Recommendation Report for Planning Permission for Works or Extension to a Dwelling

REF NO: PO/3/15/HH

LOCATION: 3 Arundel Road
Poling

PROPOSAL: Two storey side extension & single storey rear extension under green/sedum roof garden. (resubmission following PO/4/14/HH).

PROPOSED SIDE ELEVATION
East

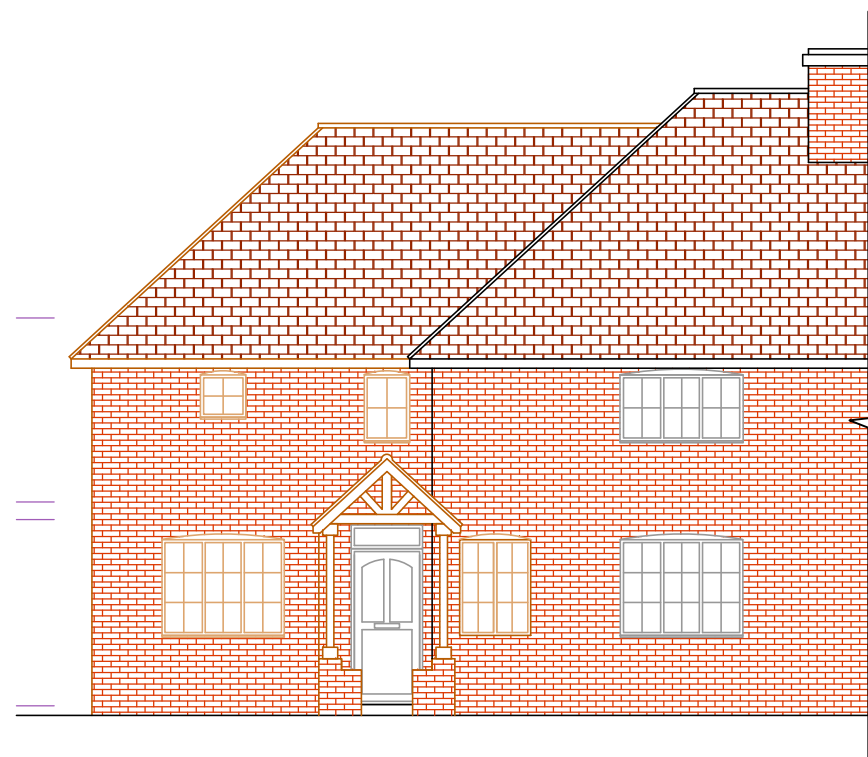
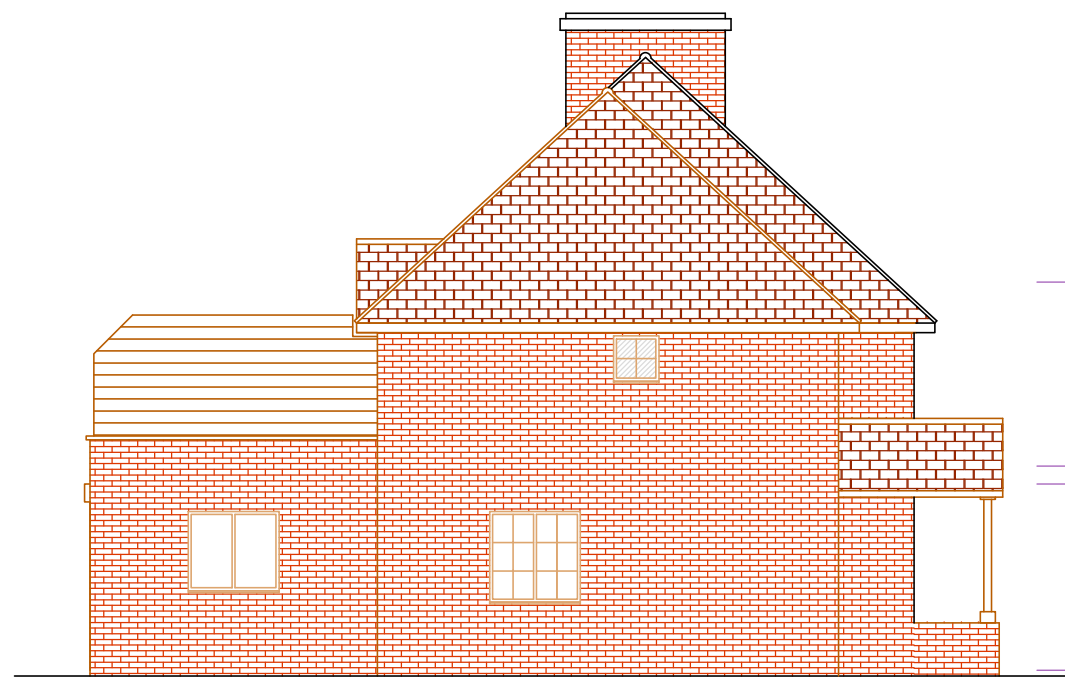
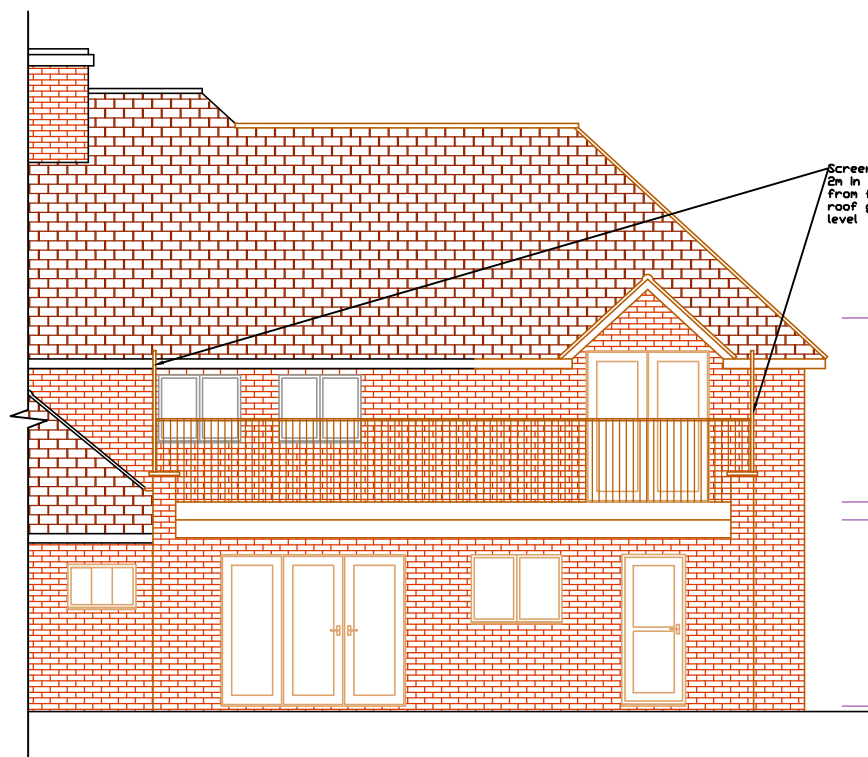
The proposed extension will bring a two-storey building element closer to the eastern site boundary, which is shared with No. 2 Arundel Road. However the side elevation will run alongside a single-storey garage wall and an adequate degree of separation will be maintained between the extension and the main dwelling building at No. 2. In addition, there will be no windows looking towards the extension except for a first floor window serving a bedroom which is conditioned to be obscure glazed. The rear projection will be set in 1.7m from the western boundary behind an existing single storey WC extension. Given these distances and the single storey height it is not considered that the rear extension would cause undue levels of overbearing towards neighbouring residential properties.

All new windows in the front elevation will face out towards the road and not look directly towards any residential property. Views from the windows on the rear elevation will look towards the far end of the site and the open fields that extend beyond it and any views towards neighbouring property from ground floor windows will be interrupted by existing site boundary treatment whilst those available from first floor windows will be at an angle and concentrated towards the end of their gardens. These views will be similar to those offered by existing windows on the rear elevation. The proposed first floor balcony would be screened by 2m high screening to preclude direct overlooking to the adjoining properties. It is therefore considered that the proposal will not give rise to intrusive levels of overlooking. The corner of the balcony screening would slightly encroach on the 45 degree, but given the limited encroachment it is not considered that a materially adverse effect would result to the residential amenities of the property to the east.

- 3 The window on the east elevation of the building at first floor level shall at all times be glazed with obscured glass and fixed to be permanently non-opening.

- 4 No windows (other than those shown on the plans hereby approved) shall be constructed at first floor level in the east elevation of the extension hereby permitted which adjoins the side boundary with 2 Arundel Road without the prior permission of the Local Planning Authority on an application in that behalf.

PROPOSED REAR ELEVATION
South

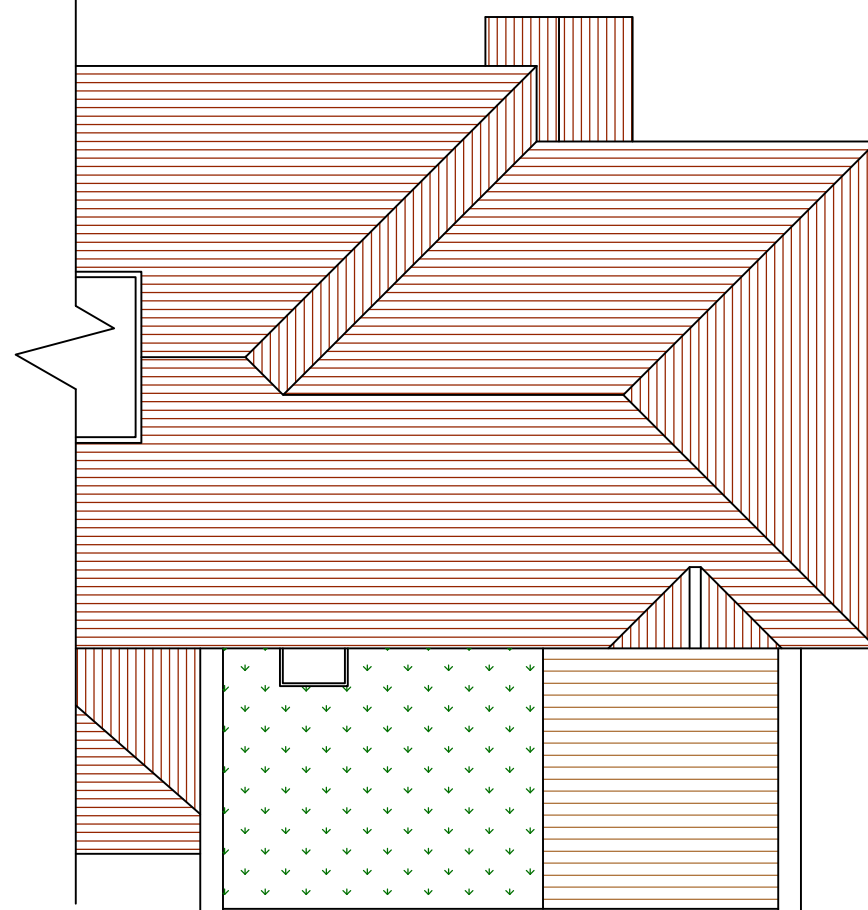
The balcony area above the single storey rear extension is proposed to have 2m high screening to both sides which would preclude direct overlooking onto the sides of the adjoining properties and the adjacent gardens. There has been no alteration to the balcony through the course of negotiation since adverse overlooking is not considered to result. The reduced footprint and set back position of the extension which has been achieved through negotiation is considered appropriate and is preferable to the flush appearance of the proposal as submitted. The extension now has less of an unbalanced appearance. Policy DEV19 requires extensions to be subservient to the host dwelling and a set back from the front elevation and reduction in roof height are considered to comply with this policy requirement. The dwelling currently has 5 windows in the east elevation, as a result of the proposal there will be a reduction to 3. It is proposed to attach conditions to ensure that the first floor window is obscure glazed to prevent a material loss of privacy to the neighbour and that no additional windows are added to the east elevation

- 5 Prior to commencement of development details of 2m high balcony screening shall be submitted to and approved by the Local planning Authority and the development shall proceed in accordance with the details so approved and the screening shall be retained in perpetuity.
